**WEST SUSSEX COUNTY COUNCIL  
STRATEGIC PLANNING CONSULTATION**

**DATE: 01/12/14**

**SUBJECT: AL/75/14/OUT - Outline application with some matters reserved for a residential development to the west of the site comprising 2 no semi detached three bed houses and 1 no detached two bed bungalow with improved access off Hook Lane with all other matters reserved.**

**Woodgate Farm, Westergate Street, Aldingbourne, PO20 3SS**

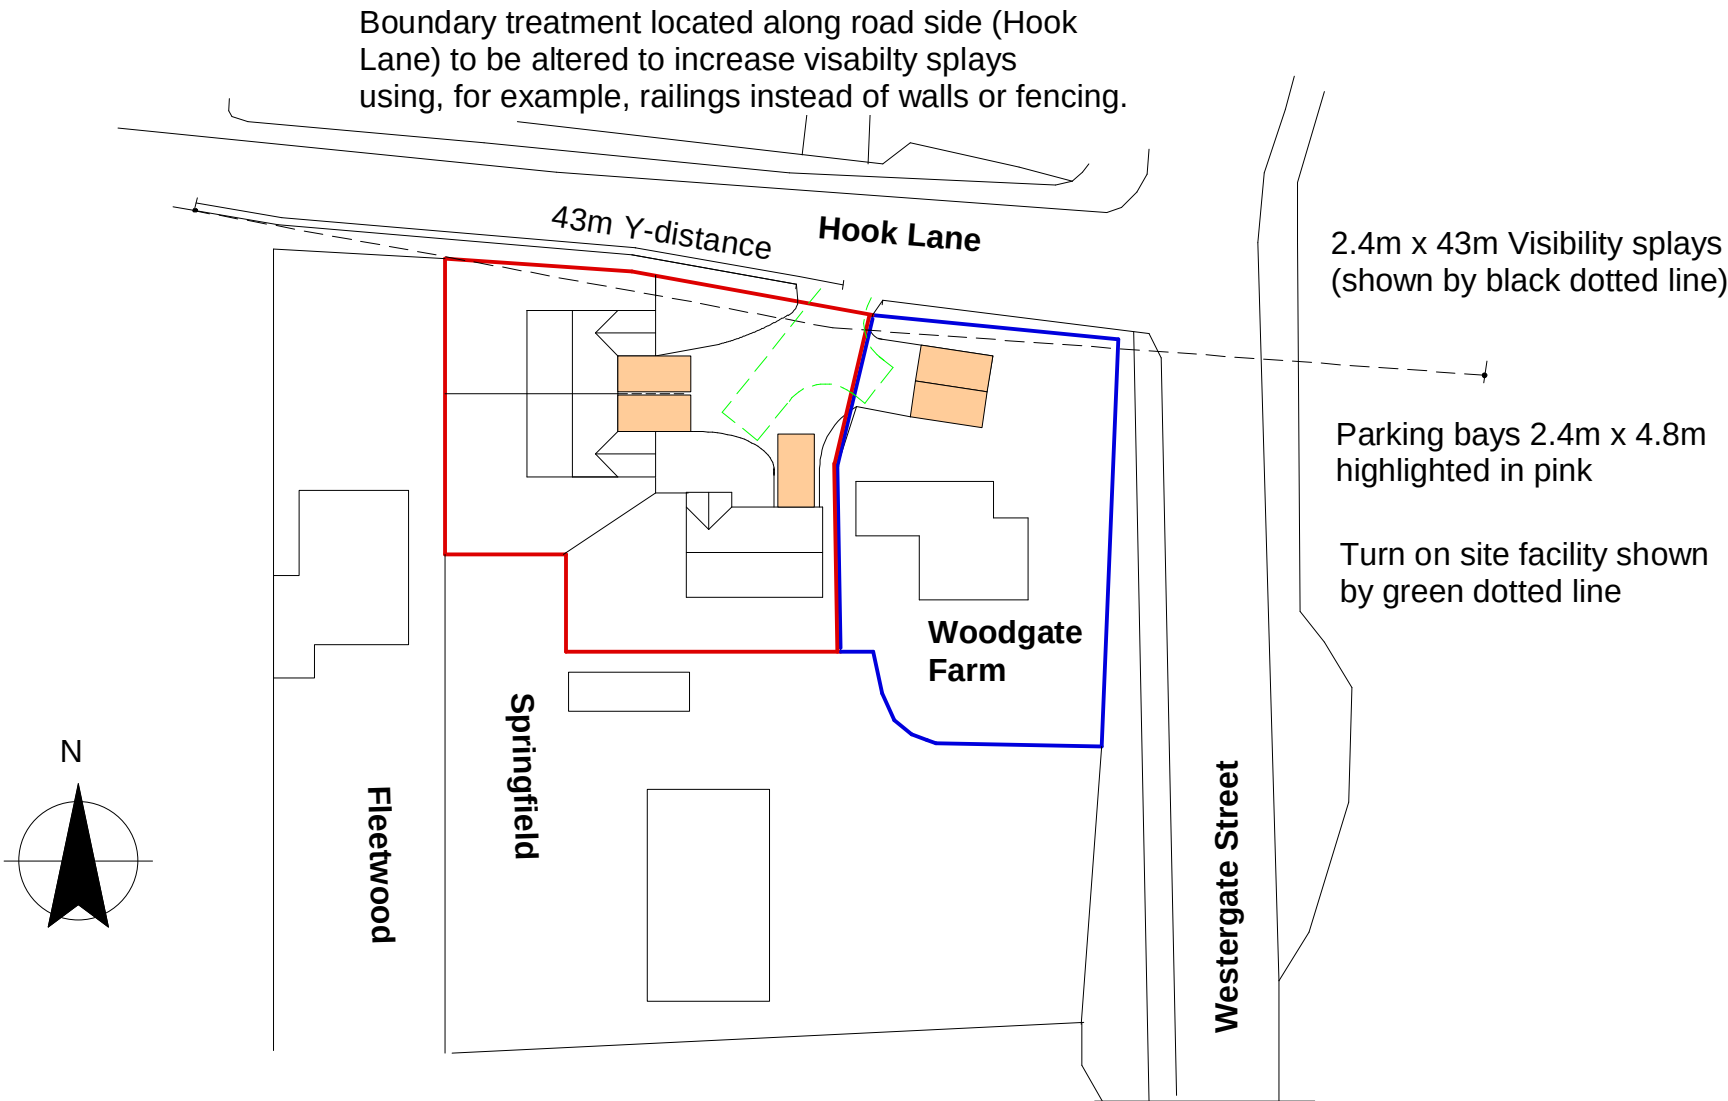
The applicant had provided a plan which demonstrates 2.4 x 43 metre vehicle visibility splays in both directions onto Hook Lane. It should be noted that the maximum achievable visibility splays to the east is 2.4 x approximately 20 metres due to the junction with Westergate Street (A29). No object within these splays should be above the height of 0.6 metres in height. The formation of these splays will therefore require significant works to the boundary treatments of the site, the impact of which is a consideration for the LPA. A 43 metre splays would be considered appropriate for 85<sup>th</sup> percentile road speeds of 30mph. To the east the maximum splay achievable is 20 metres due to the junction with Westergate Street (A29). This would equate to a sight stopping distance for vehicle travelling at 17mph. Having visited the site I would conclude that 85% of vehicle speeds approaching from the east would not likely to be travelling in excess of this speed due to the junction with Westergate Street. The applicant has demonstrated that the splays described are achievable and can be secured via condition. I therefore believe it would be difficult to substantiate a reason for refusal based on visibility at the site access point.

The applicant has demonstrated that 5 car parking spaces will be provided and all will be afforded the ability to turn on site and so that entry and exit to the site can occur in the

forward gear. Each of the new dwellings appear to be allocated one space while the existing Woodgate Farm appears to be allocated two spaces. Based on the latest dwellings sizes and parking allocation above I would anticipate a development of this size in this location to attract the demand for 8 vehicles. This shortfall of 3 spaces would have to be provided by on-street car parking, likely on Hook Lane, where on-street car parking does occur with no restrictions. Having visited the site I believe it would be difficult to substantiate that this additional on street car parking would result in a highway safety issue, nevertheless the LPA may be minded to consider the on street car parking amenity of other residents.

The access widening works on the public highway must be conducted under license to a specification obtained from WSCC highways. The internal hard standing parking and turning area should be constructed in a bound surface.
